**A66 Northern Trans-Pennine Project
TR010062**

6.1 Errata Report (Rev 3)

**6.1 DEVELOPMENT CONSENT ORDER ERRATA REPORT
(REV 3)**

Planning Inspectorate Scheme Reference	TR010062
Application Document Reference	6.1
Author:	A66 Northern Trans-Pennine Project Team, National Highways

Drawing Title: Classification of Roads Plan Regulation 5(2)(o)
Sheet 1 of 1

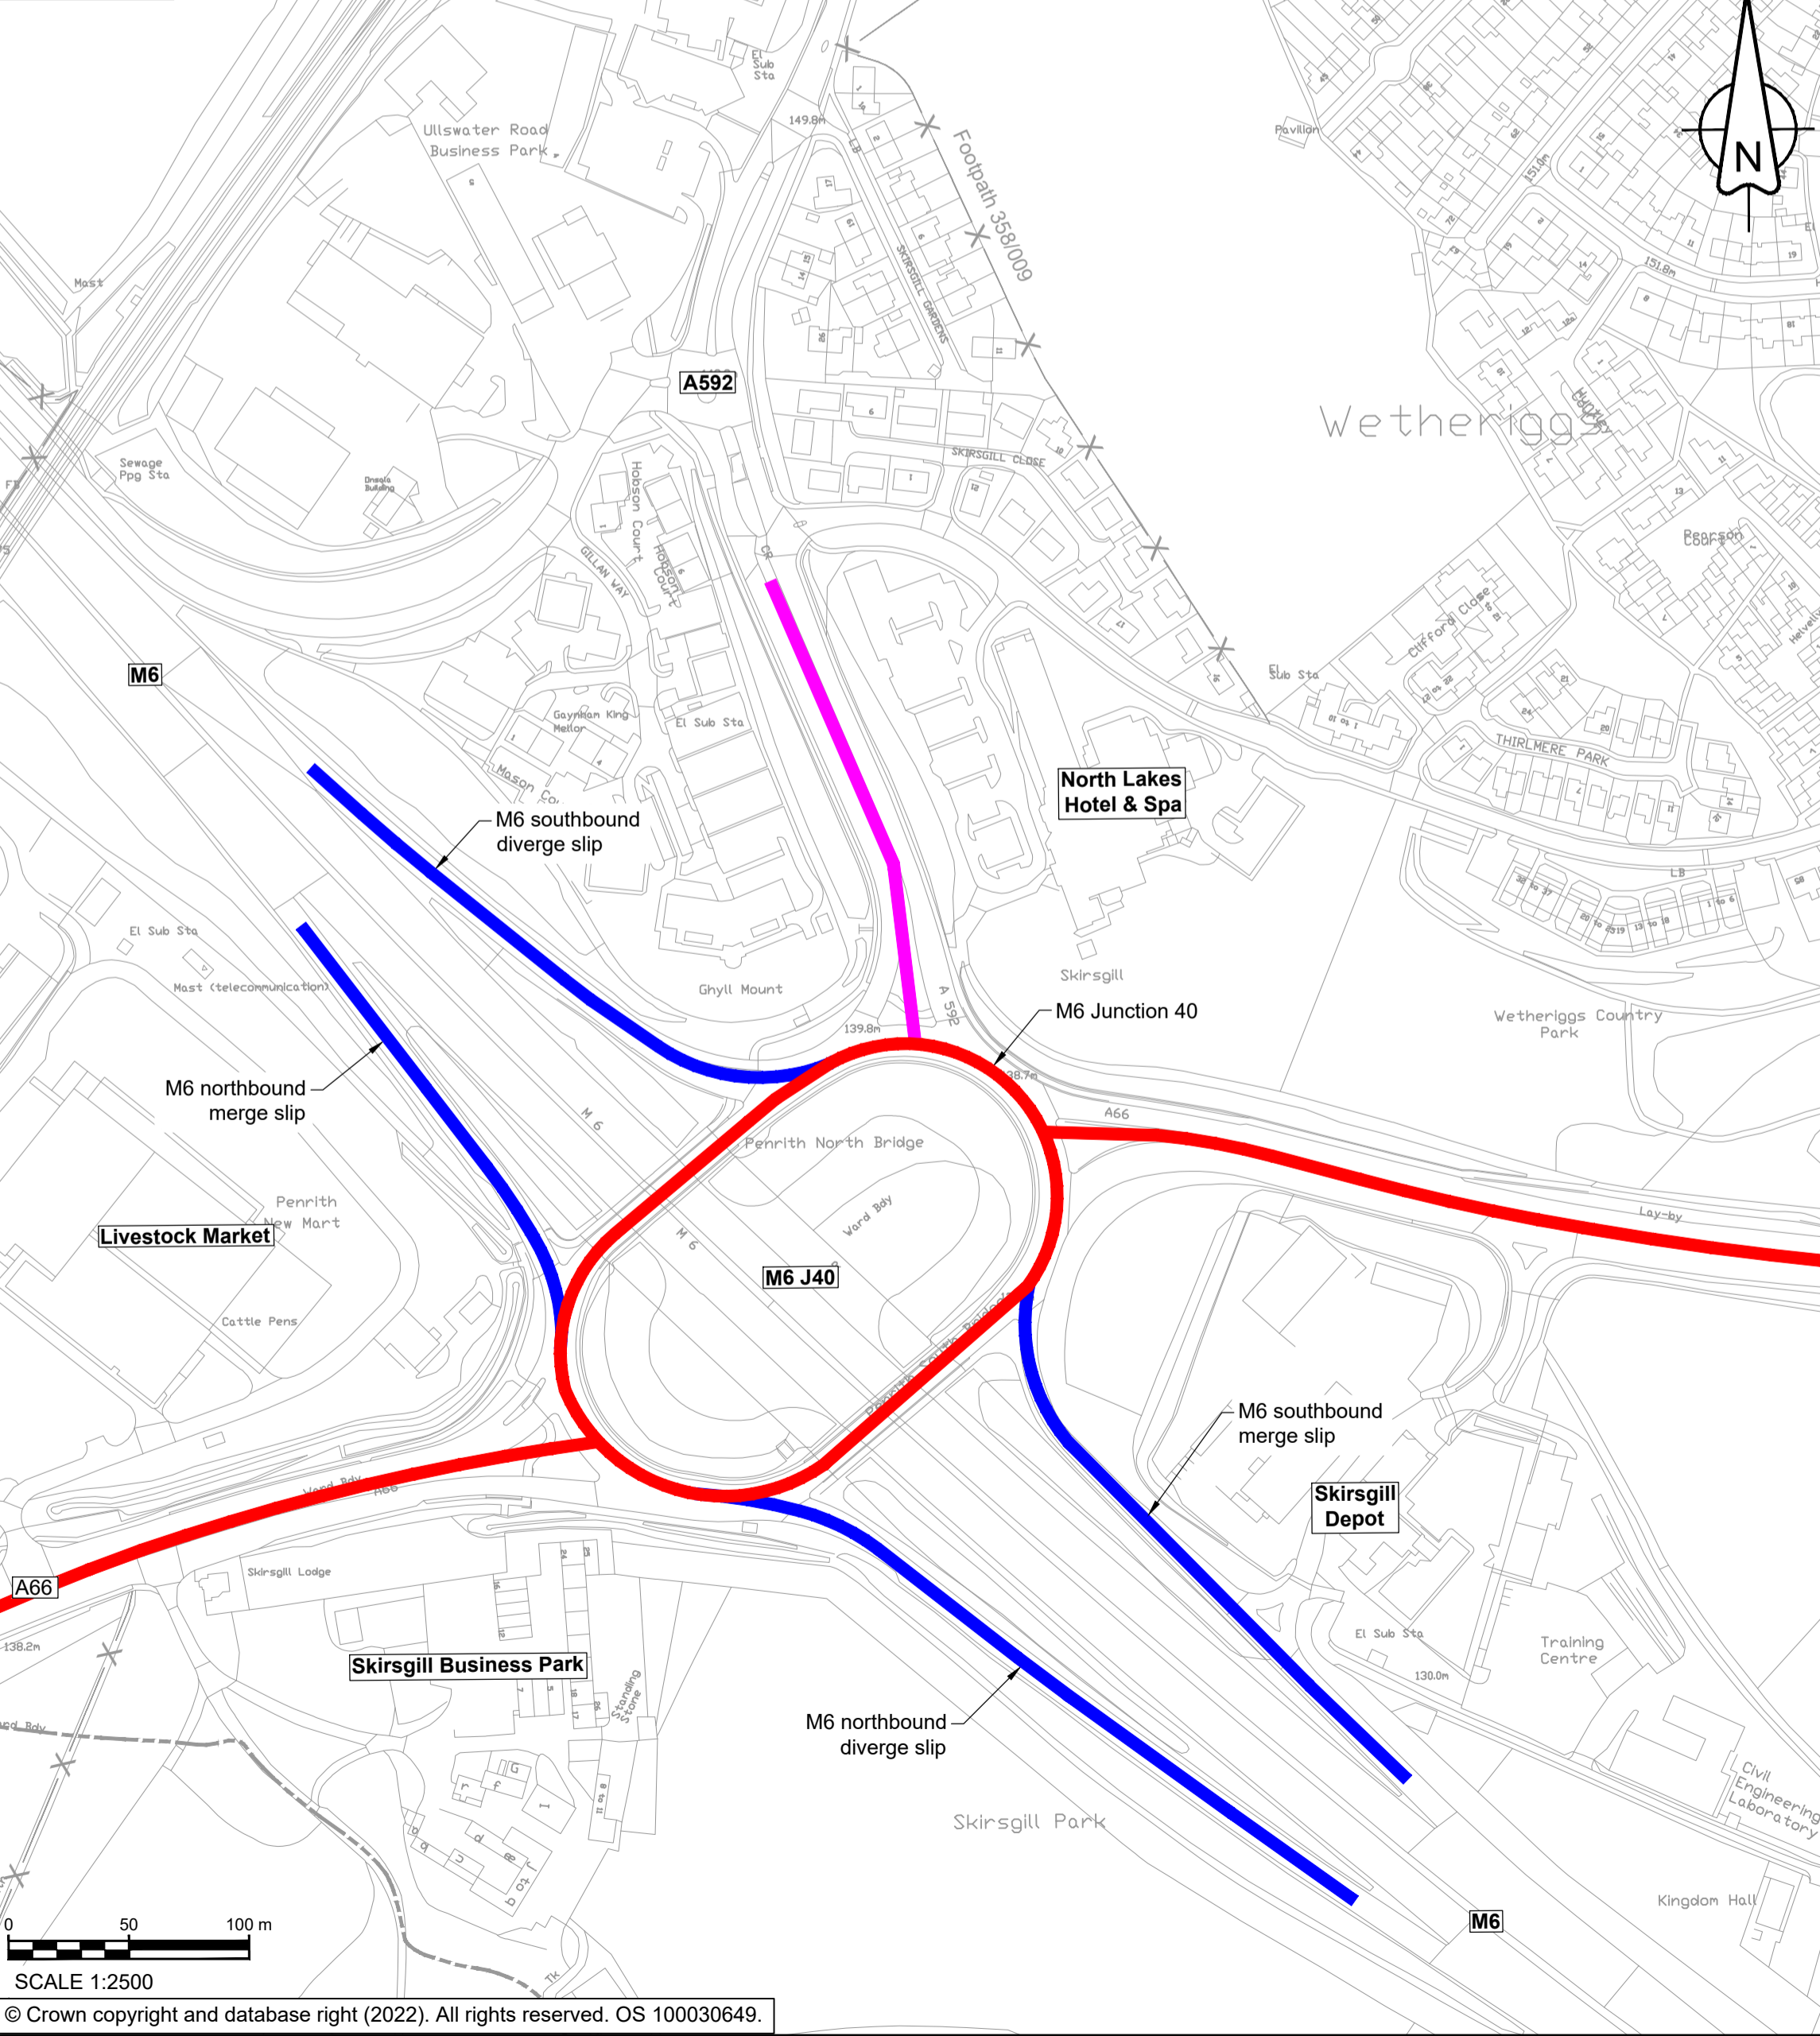
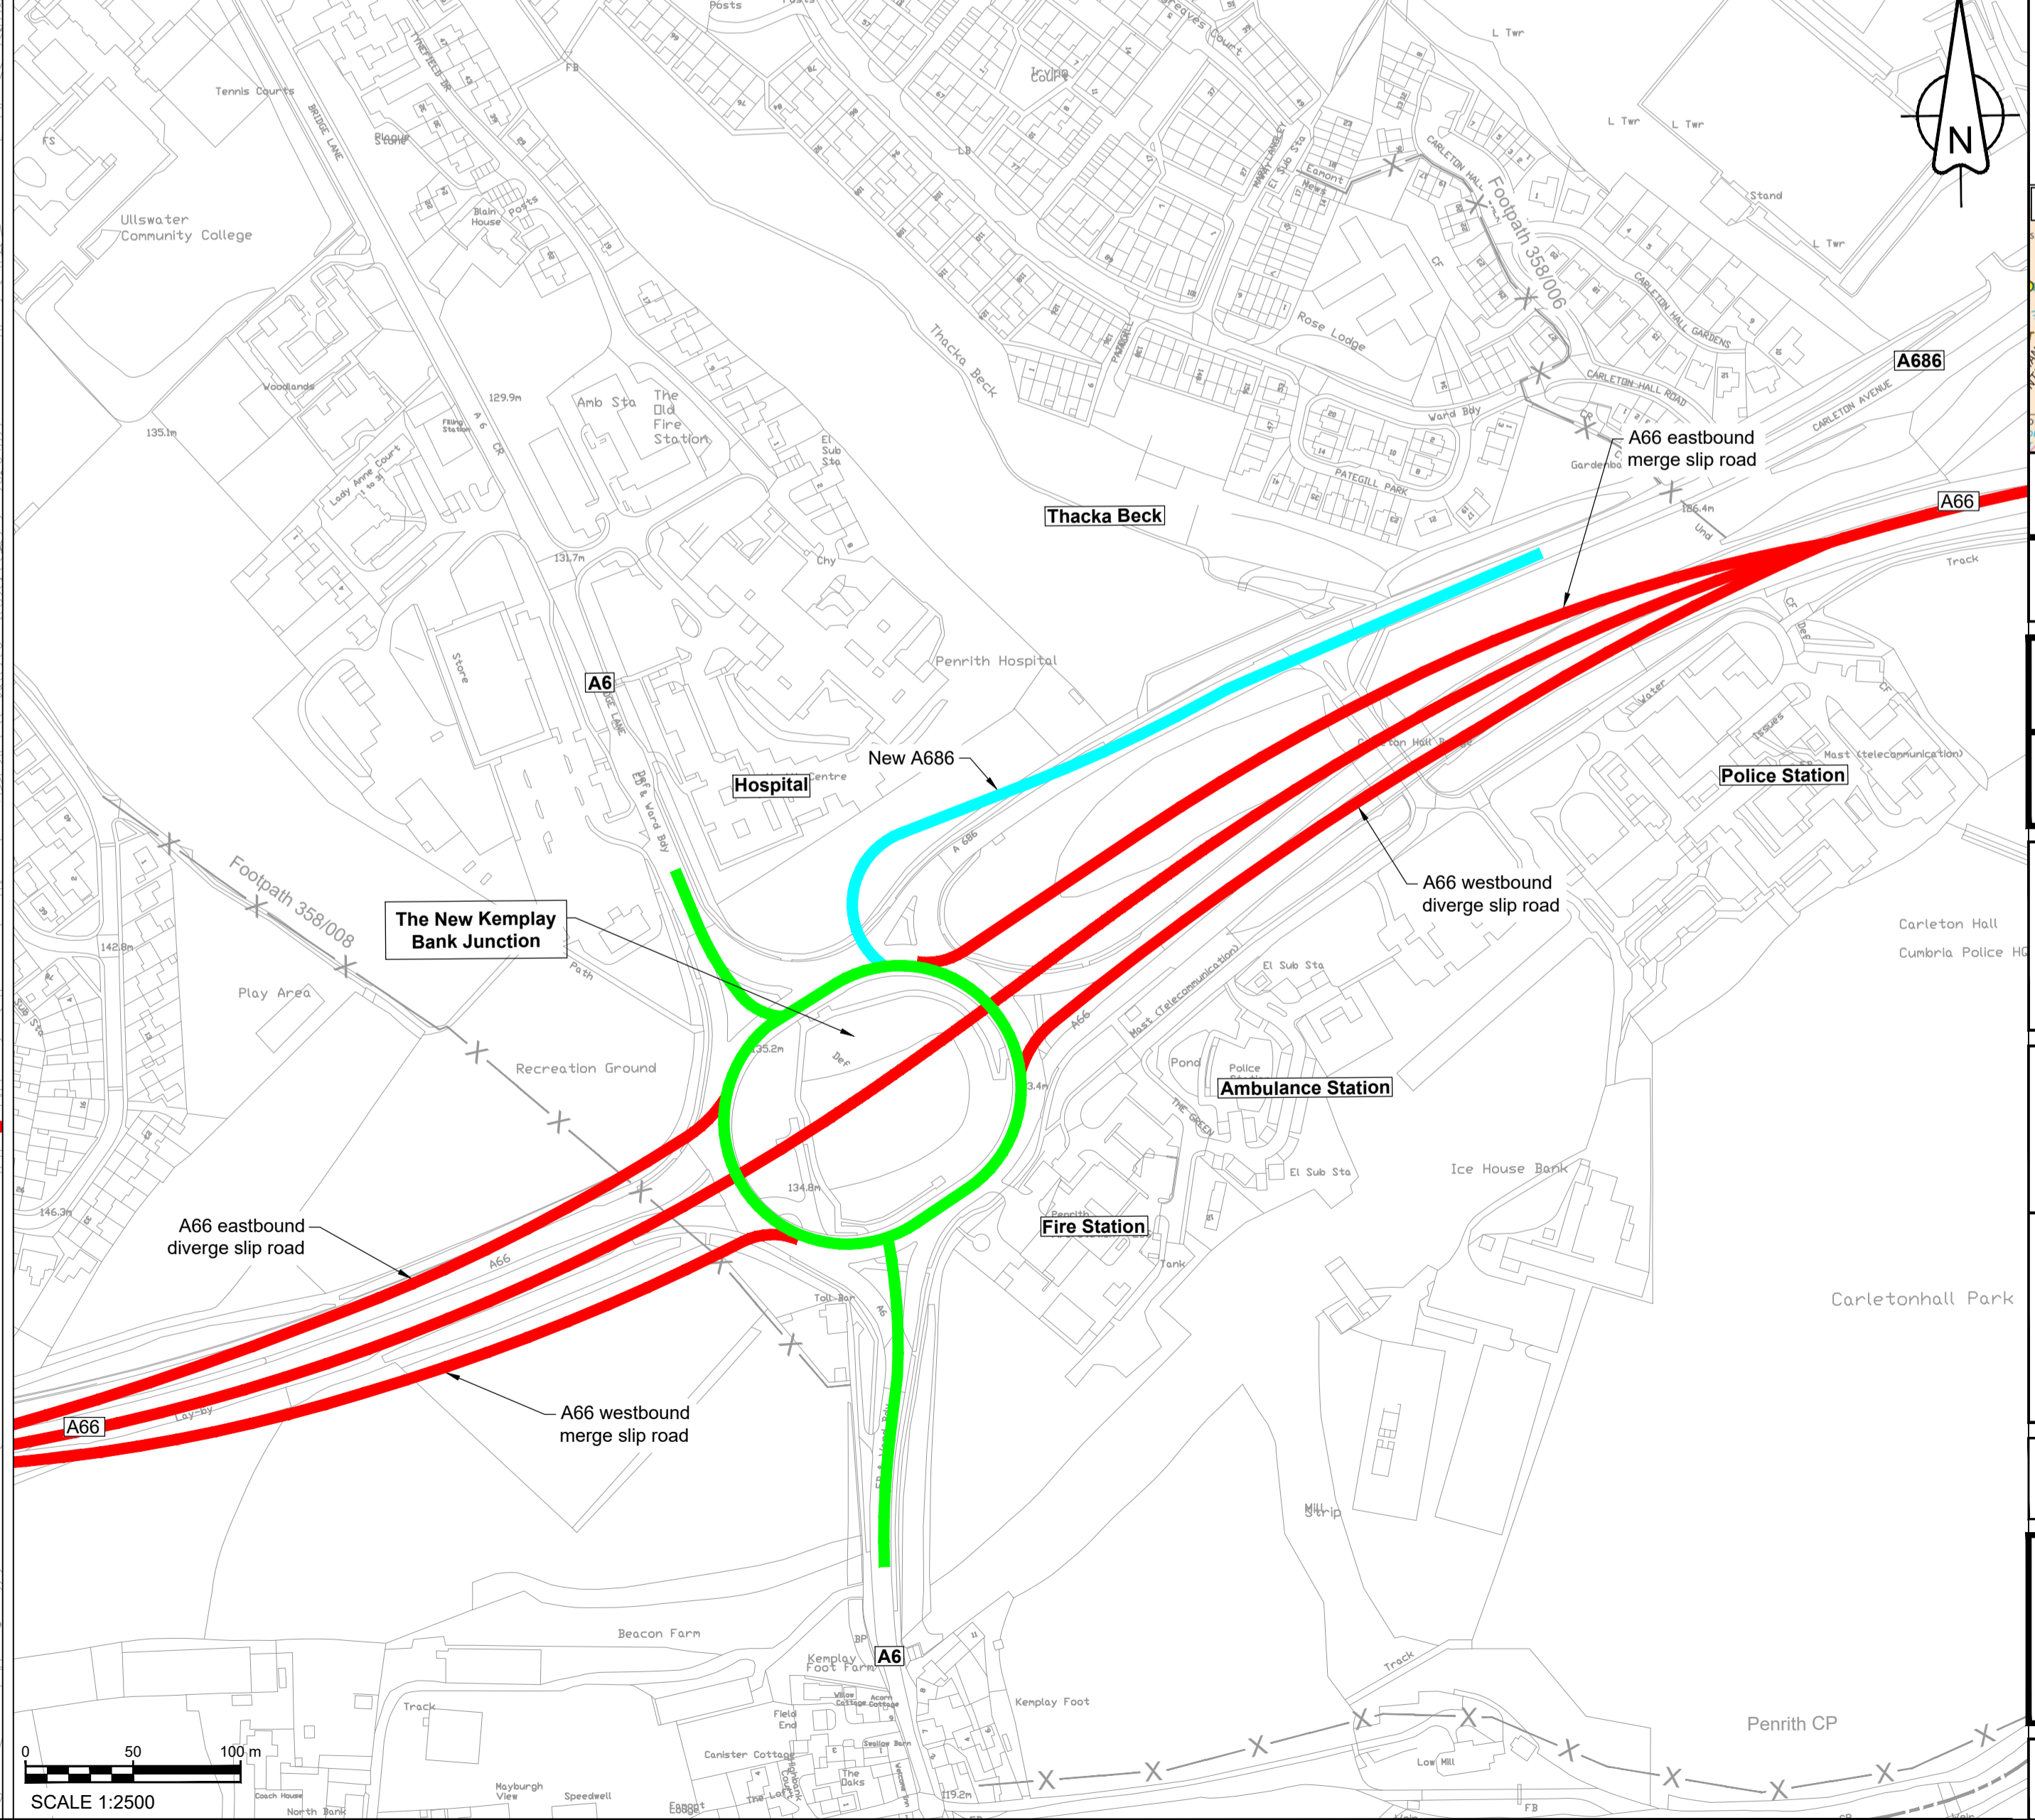
Nicholson	34 124ha	12.59 20.8ha	8.2 14.2ha	4.3 6.6ha	Negligible	High	Permanent minor adverse	Moderate adverse	
	Baseline summary for the Nicholson land holding	Incorrect reporting of Nicholson total plot area	34ha 124ha of land							No update to Appendix 13.2.		
REP7-133 - 5.20 (Rev 2) Classification of Roads Plan Scheme 06 Appleby to Brough	Sheet 1 of 2	Naming of roads	B1066 replaced with C3077 in both plan and legend following agreement with Westmorland and Furness Council.							Updated to 5.20 (Rev 3) and issued at Deadline 8
